Your Ref: OWPC22322
Our Ref: BR/76/19/PL 11-03-2019
Please ask for:
Stuart Corbey

Conversion of existing house into 2 No. 3 bed semi detached properties.
Alloways 33 Shelley Road Bognor Regis

Thank you for your internet representation made on 24th April 2019 which has been recorded as '**an objection**' with the comments as follows:

No.	Revision/Issue	Date
Proposed Conversion Proposed Elevations Planning		
Date March 2019		
Scale 1:50

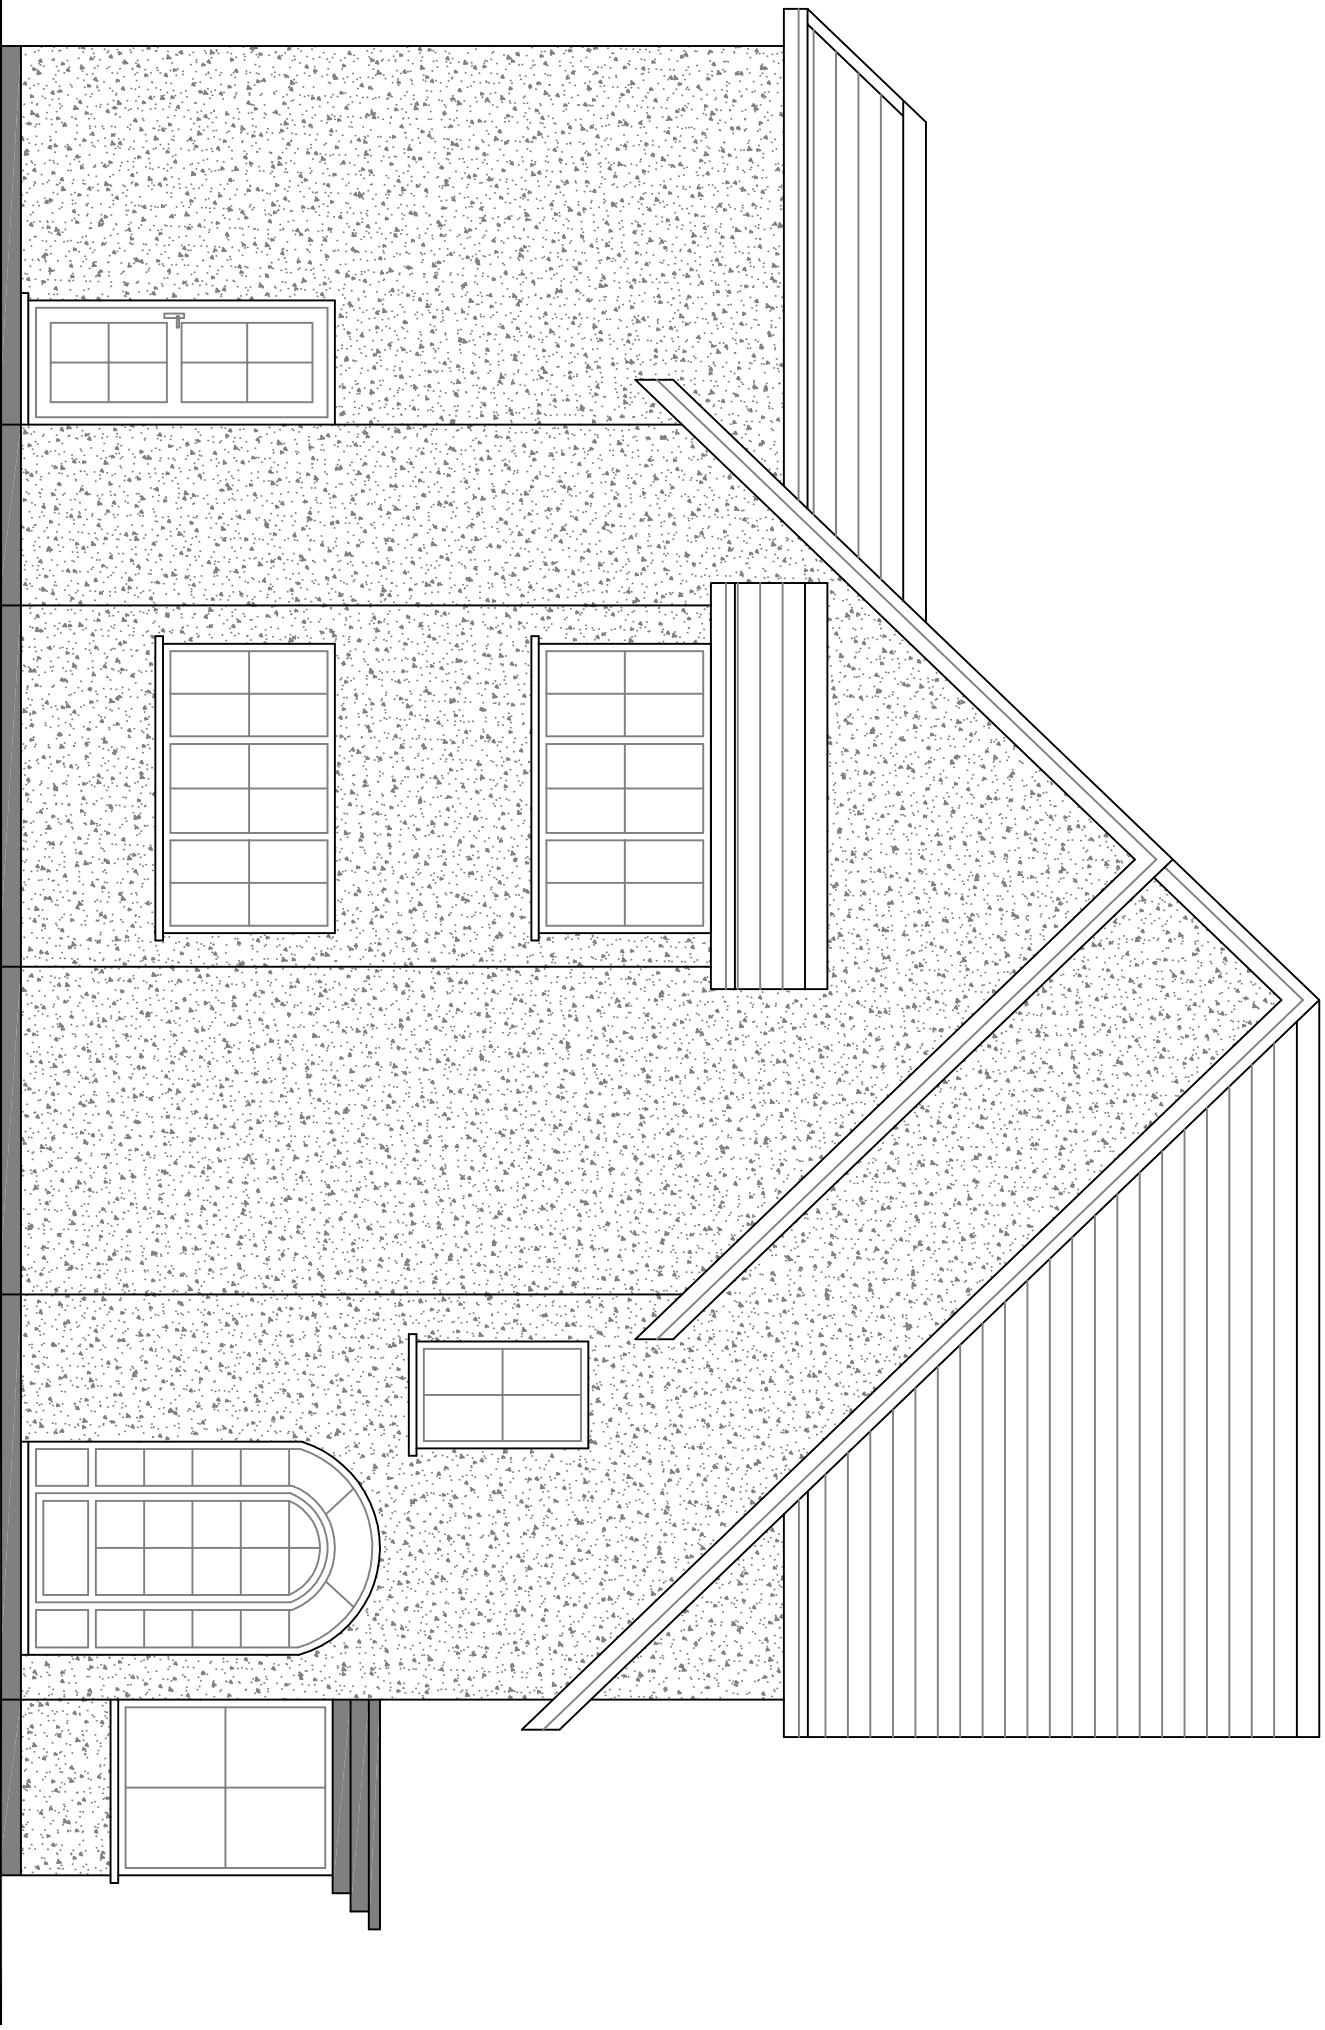
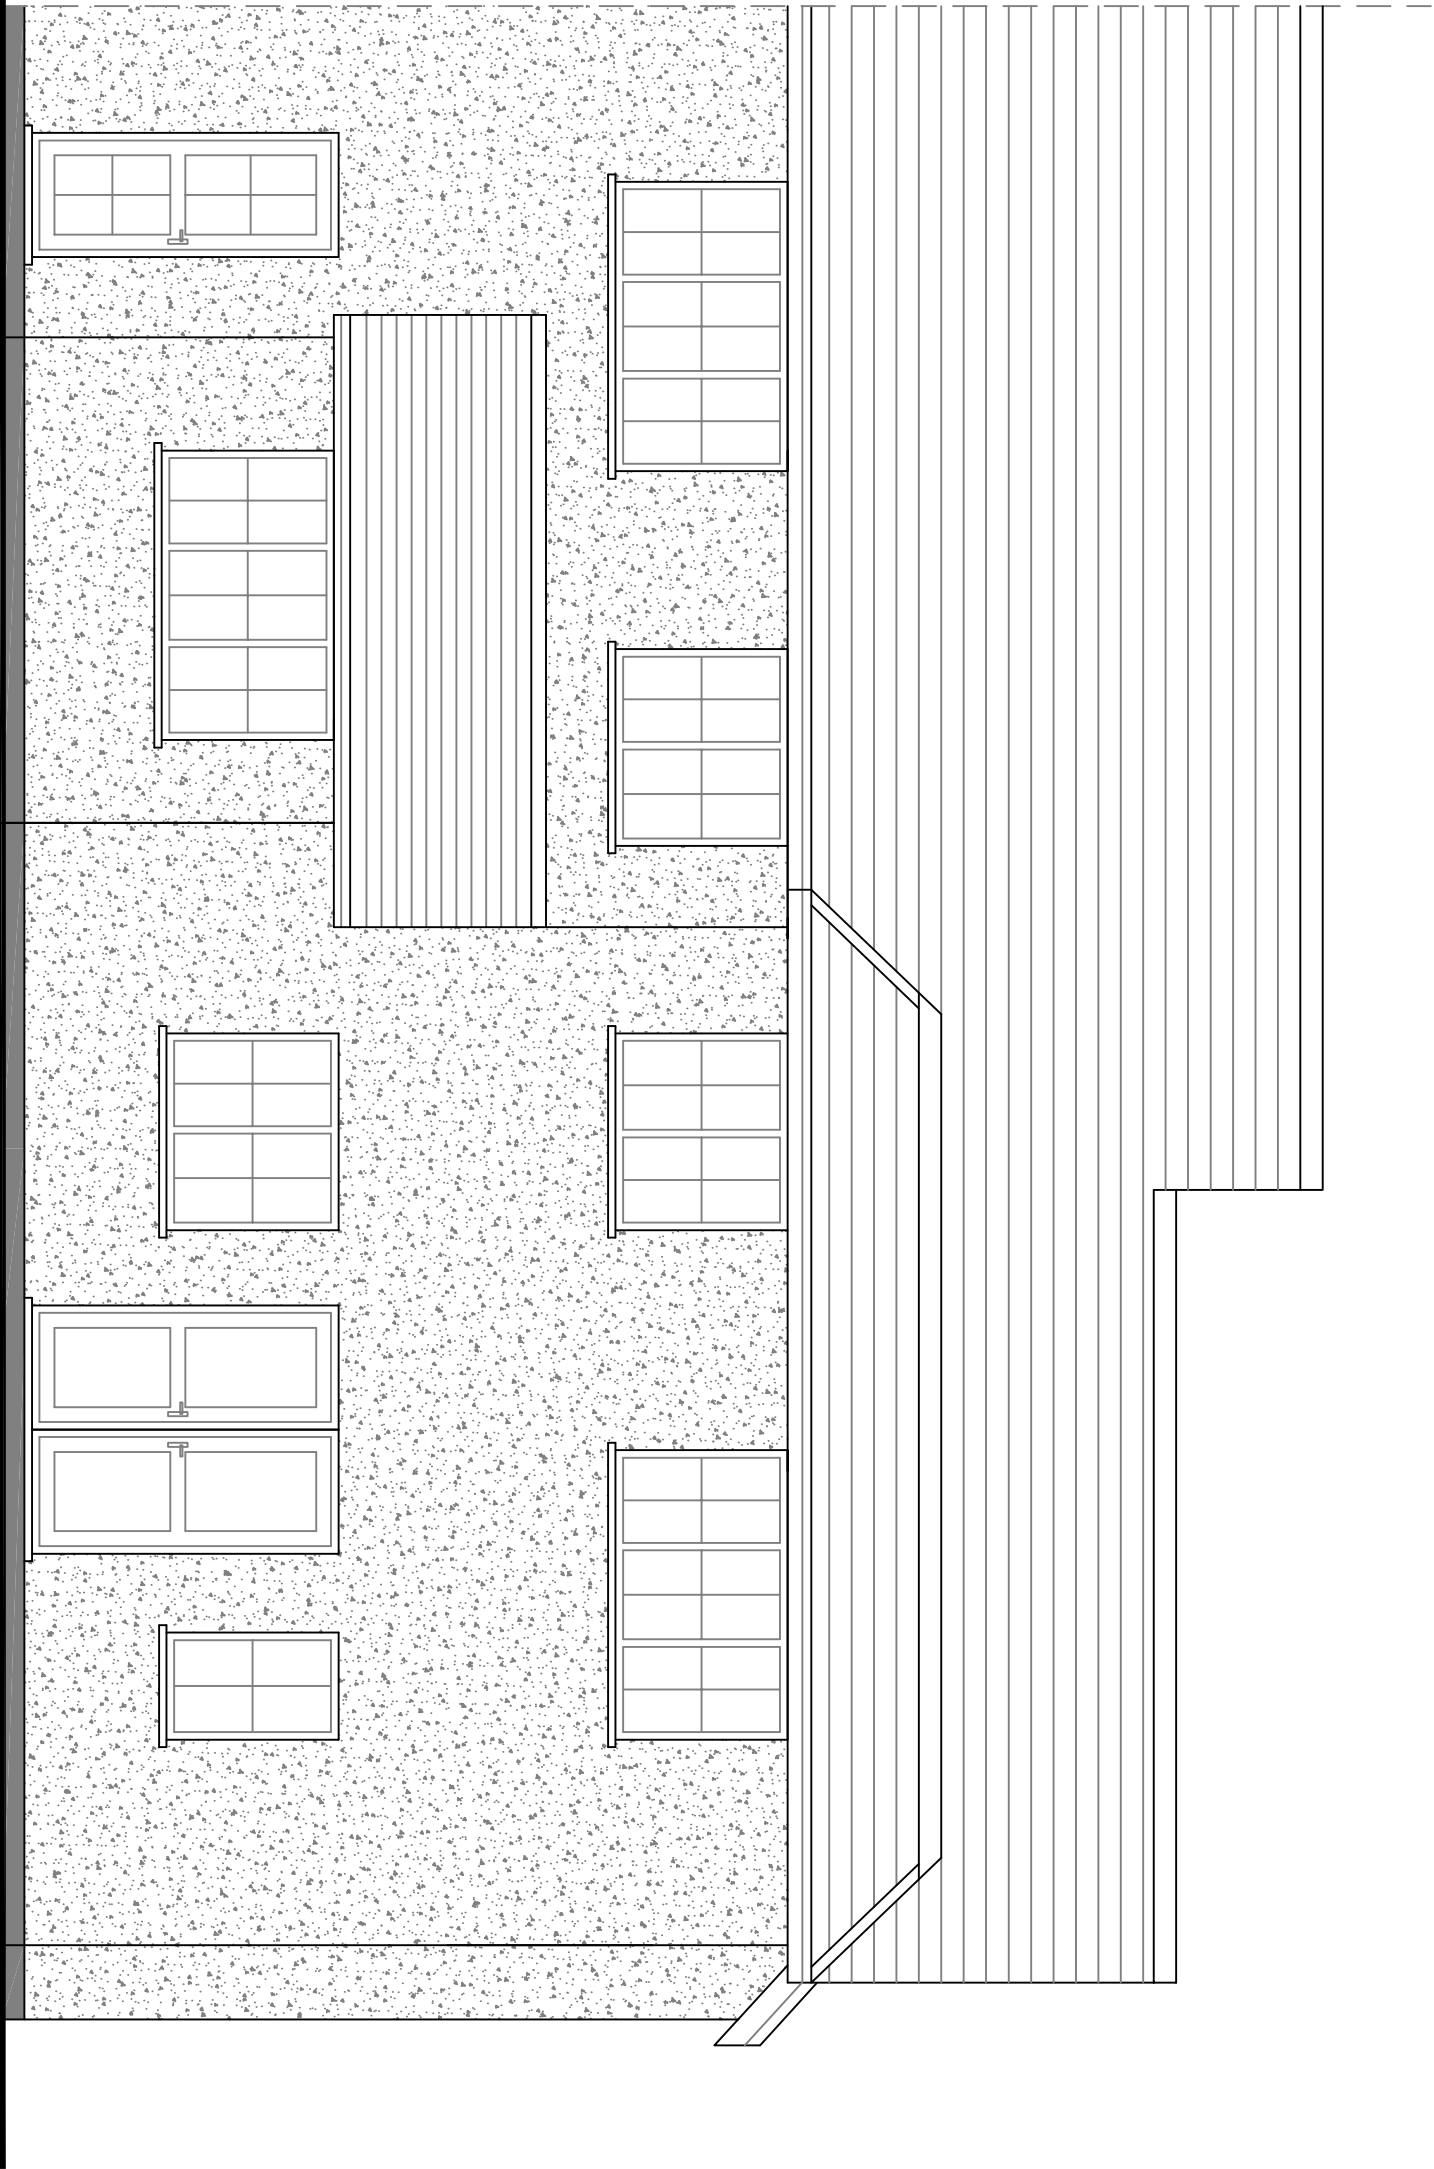
I have viewed the plans and am concerned that the bay window at the front of the property will be removed to make room for cars to park at the front of the property. This destroys the facade of the house and ruins the character of the property. If the bay window is not removed the cars will not fit on the front of the property meaning they will have to be parked on the street creating worse parking conditions.
